11 October 2011

**S.75W MODIFICATION TO MP10\_0057 – RESPONSE TO ISSUES  
132-138 KILLEATON ST, ST IVES**

**KU-RING-GAI COUNCIL LETTER**

CARPARK LEVEL 2 STAGE-2
SCALE 1:200

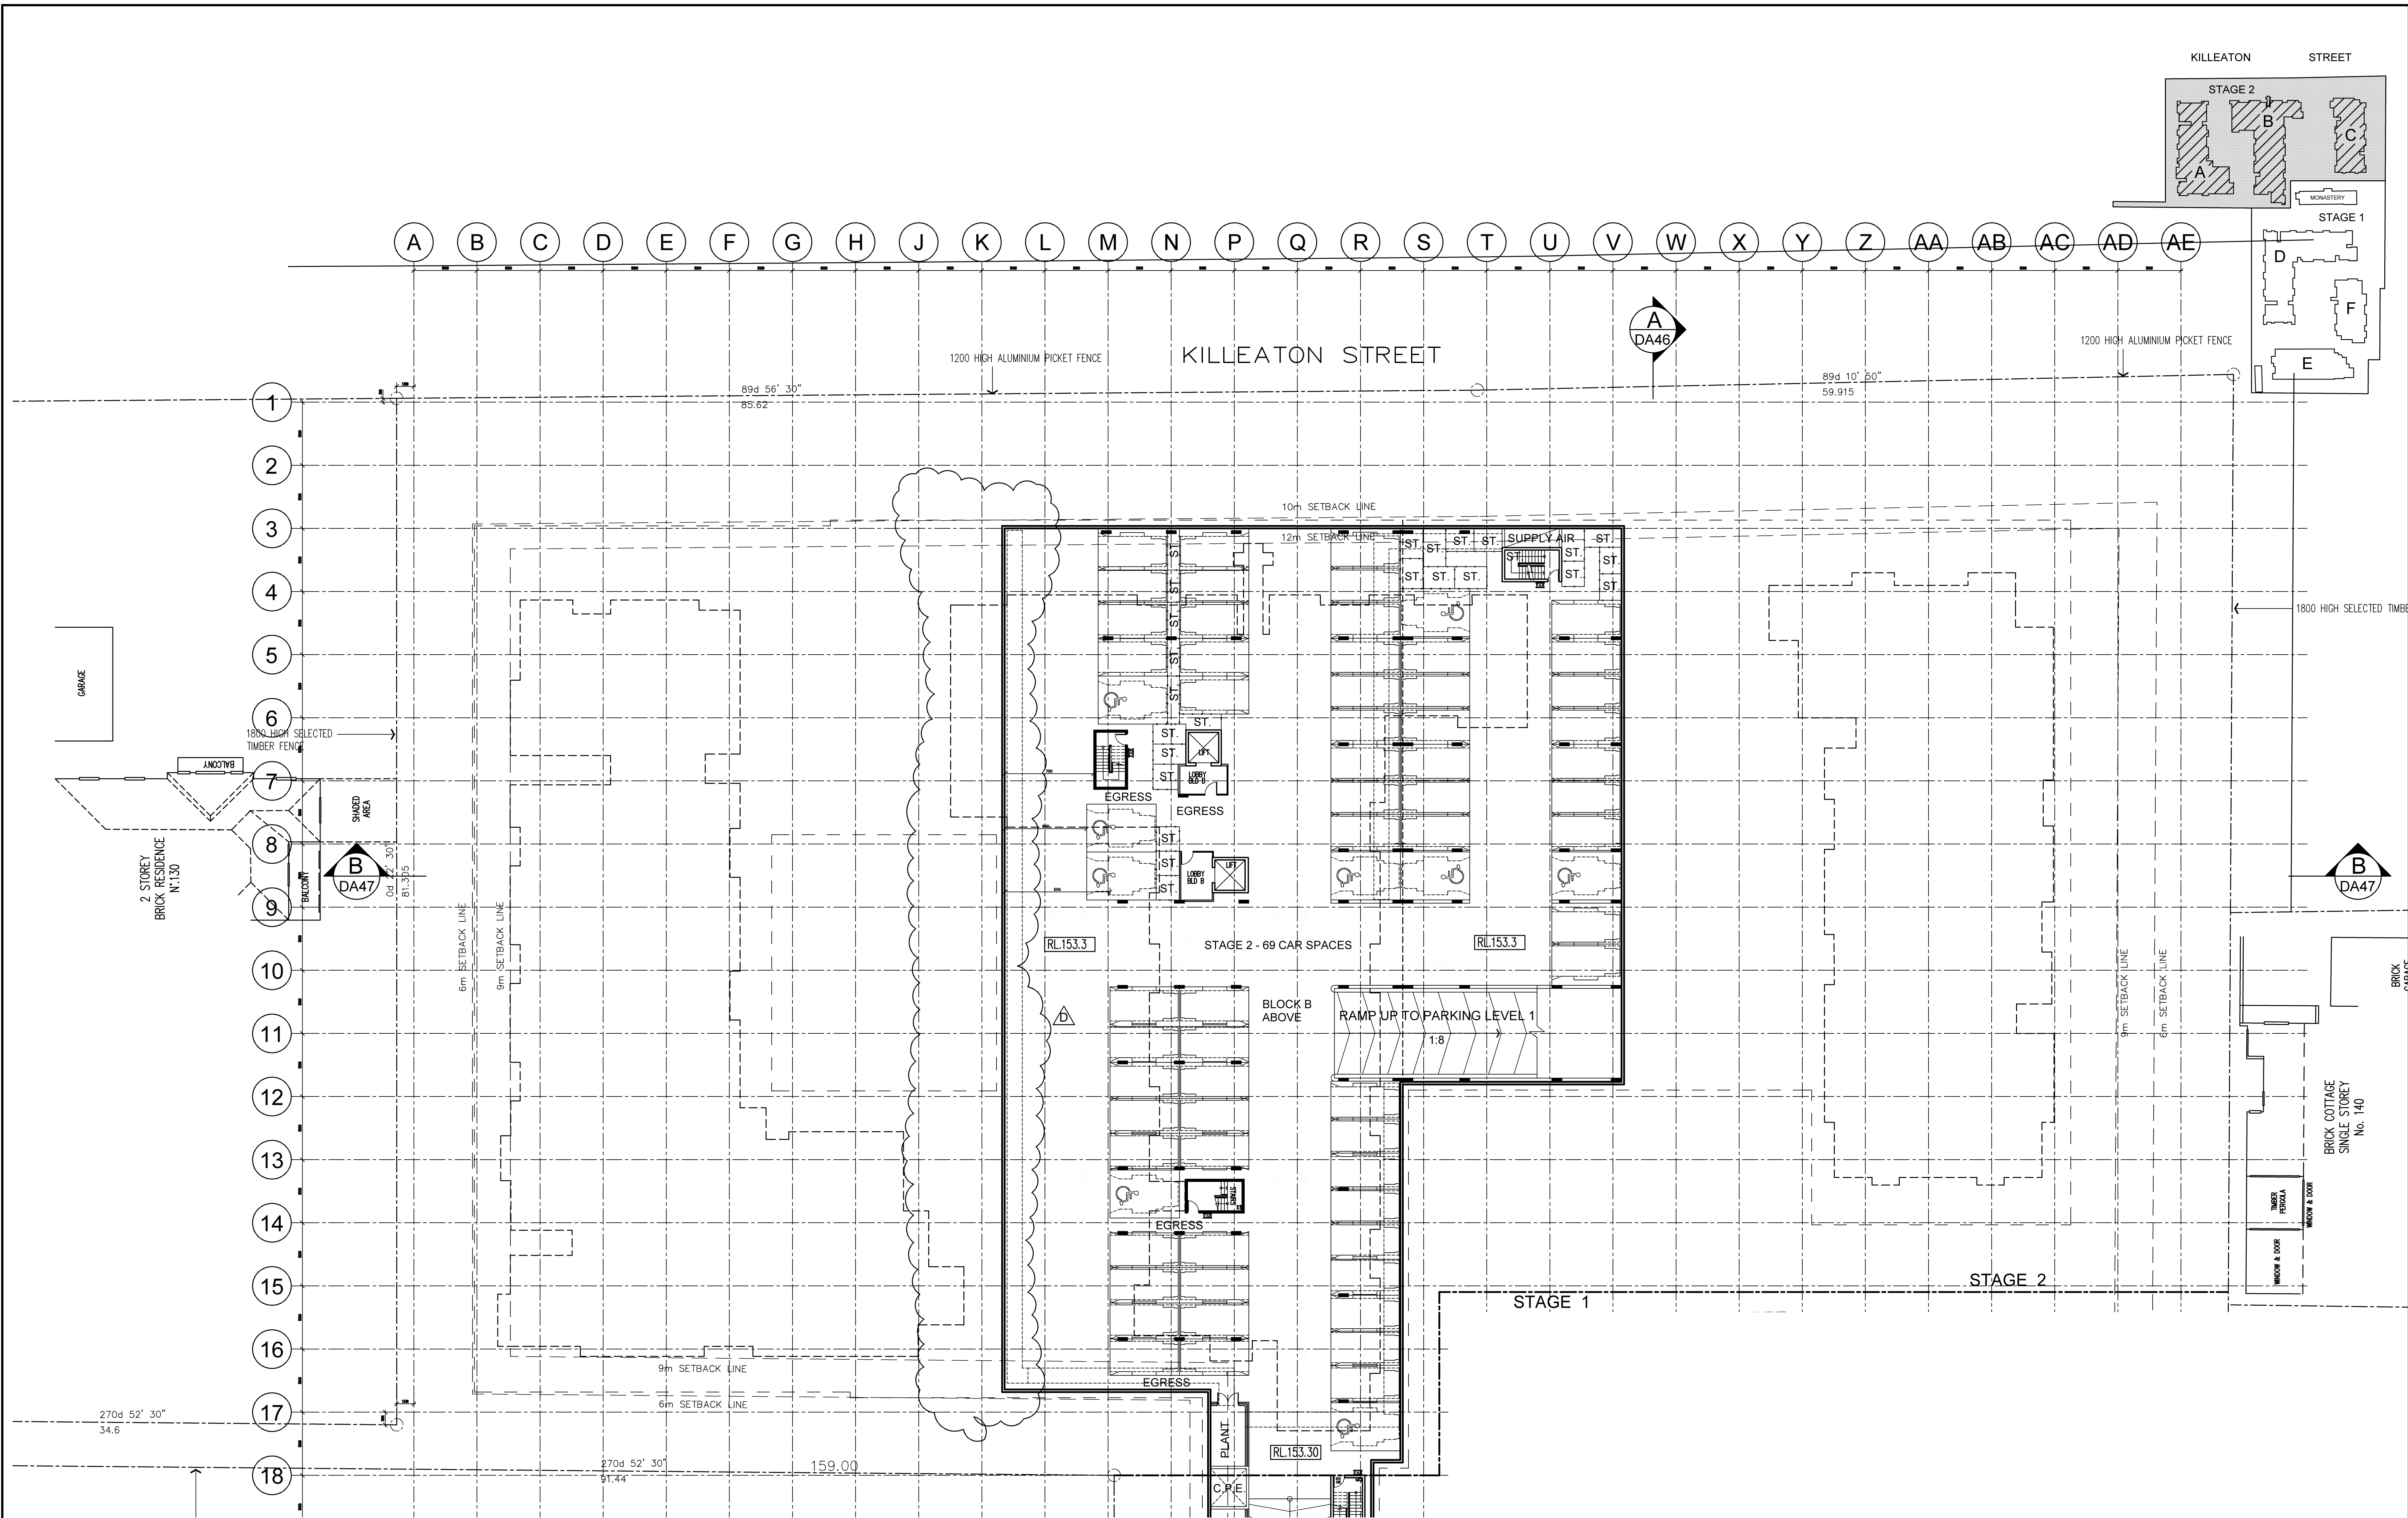
The Council argues that the visitor parking provision should remain at 75 parking spaces (instead of 48 as proposed) because the site is not located in a town centre or on railway line.

As detailed in our application and in the traffic report accompanying our application, the subject site is well serviced by bus transport. Those bus services include transport links to the nearby railway stations.

It is considered highly unlikely that 75 individuals (all of whom are driving a car) will be visiting the site at any one time. Indeed, it is also considered unlikely that 48 individuals (driving a car) would be visiting the site at any one time.

The Council's argument also relies on data that relates to resident parking. We seek no change to the resident parking provisions on the site.
